From: Sarah Fawdry [REDACTED]
Sent: 02 March 2023 15:55
To: Jessica Riches; David Easton
Cc: Chris Brake; Katie Martin; Martin Kempshall; Thomas Richards; Silvie Steiningerova
Subject: Bilsham Road, Yapton - Y/70/22/DOC and Y/34/22/DOC
Attachments: 2023 02 08 Y 70 22 DOC Drainage Response.pdf; D1956-13-200B Proposed Levels Layout.pdf; D1956-13-201B Proposed Levels Layout.pdf; D1956-13-202B Proposed Levels Layout.pdf; D1956-13-300B Proposed Permeable Paving Formation Levels.pdf; D1956-13-301B Proposed Permeable Paving Formation Levels.pdf; D1956-13-302B Proposed Permeable Paving Formation Levels.pdf

Having recently picked up comments on your online portal regarding Y/70/22/DOC (dated 8 February 2023; attached for ease), please find our responses to the outstanding queries as follows. For ease and completeness, I have followed on from the previous queries with our responses, our latest response is detailed in green.

HEADWALL SECTION A-A  
(1:20)

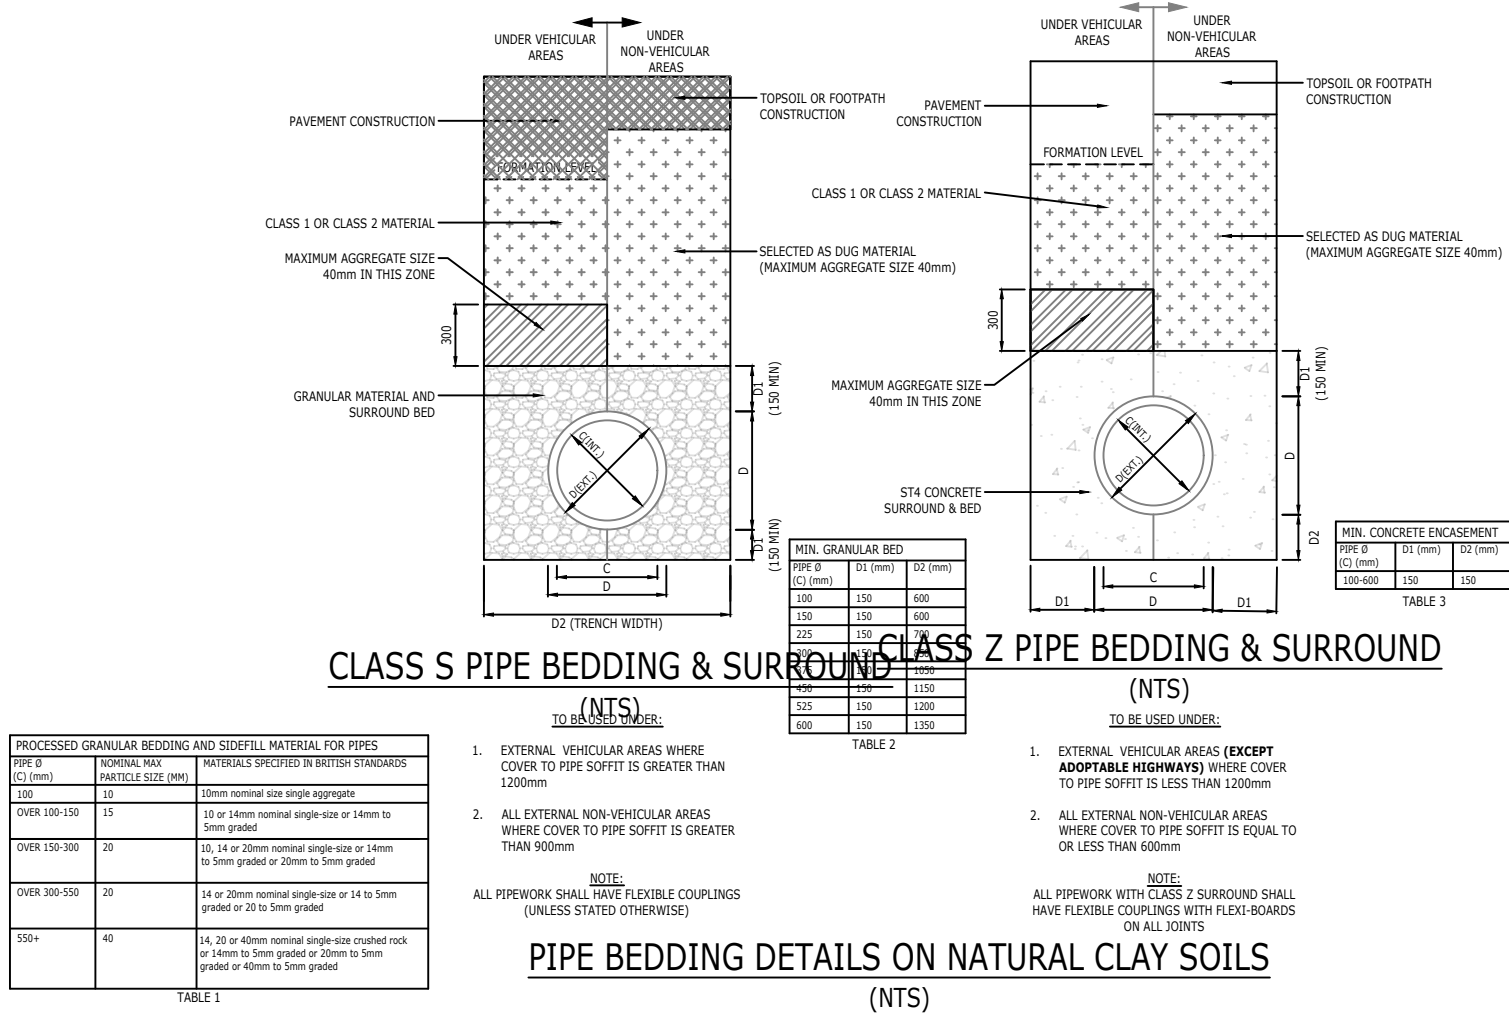
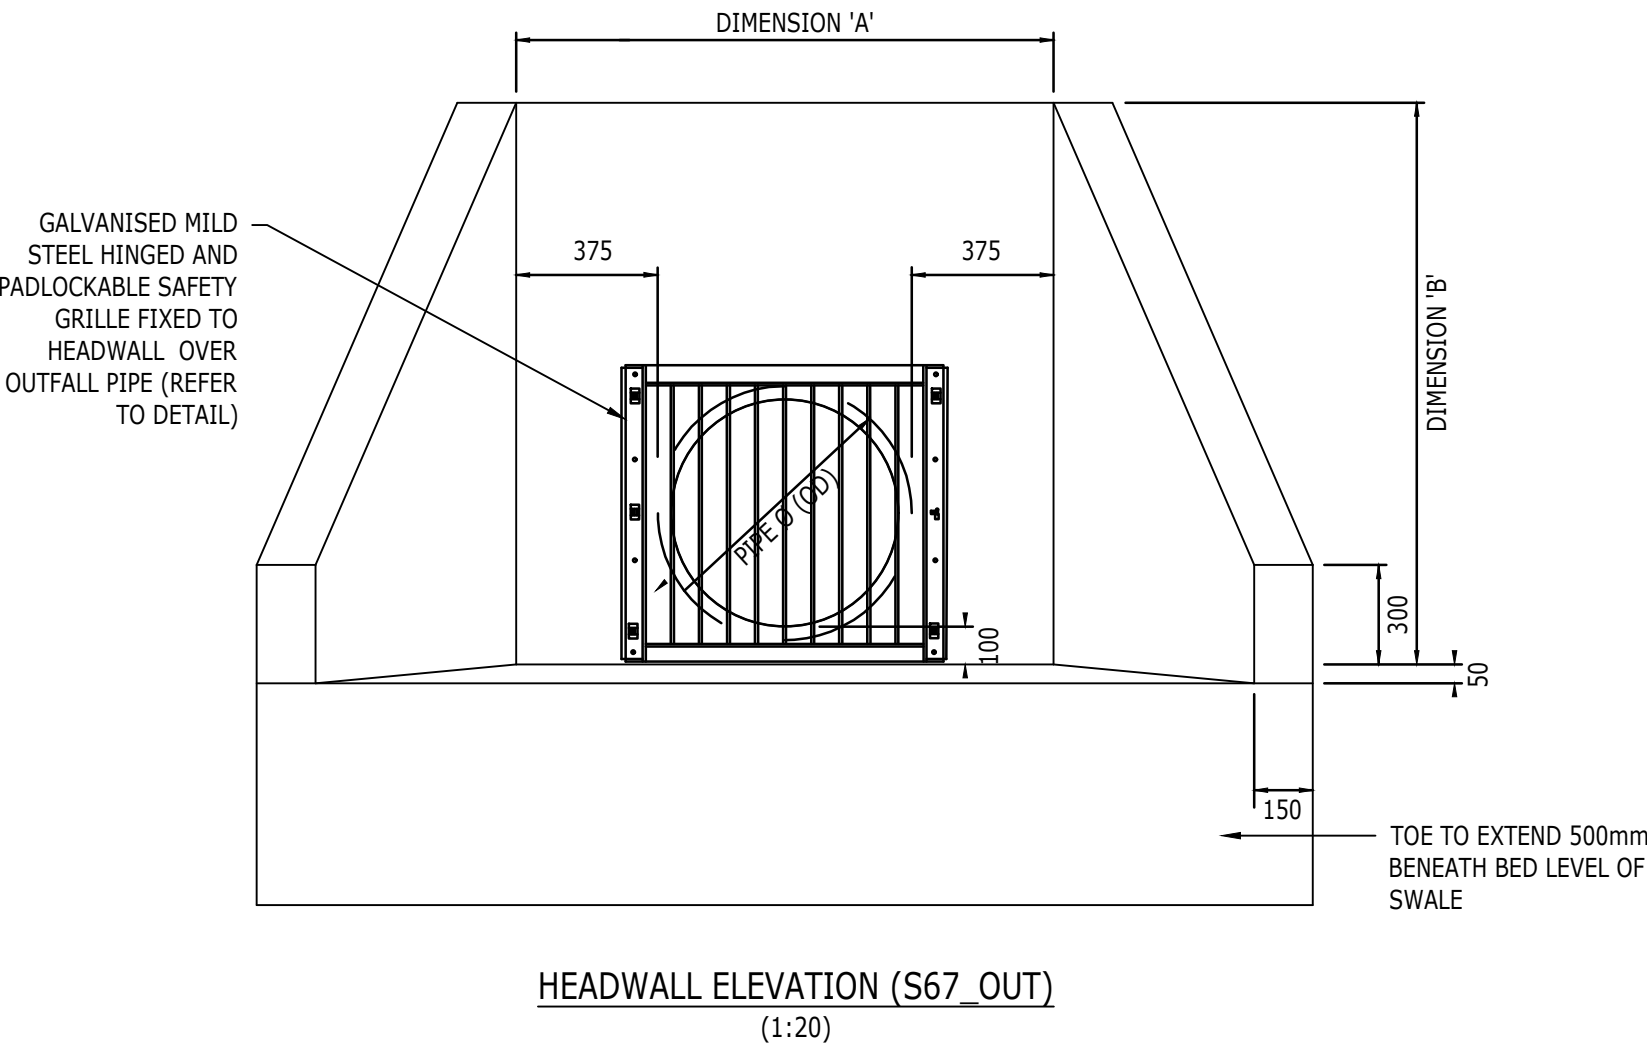
11. Please provide cranked grilles at a 45 degree angle. - Cranked grilles required on heads – S104 Construction details sheet 1 of 2 D1956-15-100 needs to be updated to suit ADC requirement. Pipe beddings details on this drawing are illegible in parts. Information needs to be clearly presented. We note that applicant's response that this is not "DSG compliant" however the drawings refer to Sewers for Adoption 7th Edition. As such the applicant needs to be clear which edition of Sewer for Adoption the adoptable drainage is being designed to. In addition they should confirm who the adopting authority will be as well as confirmation from the adopting authority on whether they will or will not accept cranked grilles. 08/02/2023- Whilst it is noted that the Technical Approval certificate has been provided for information, this doesn't clarify whether the adopting authority has considered a request to use cranked grilles. This needs to be confirmed by the adopting authority otherwise cranked grilles should be used TH: There is no provision in DCG for the use of cranked grilles, only grilles installed flat against the headwall. In addition, we consider that cranked grilles create a health and safety issue as they could encourage people to climb up on them up to a perch from which people could fall.
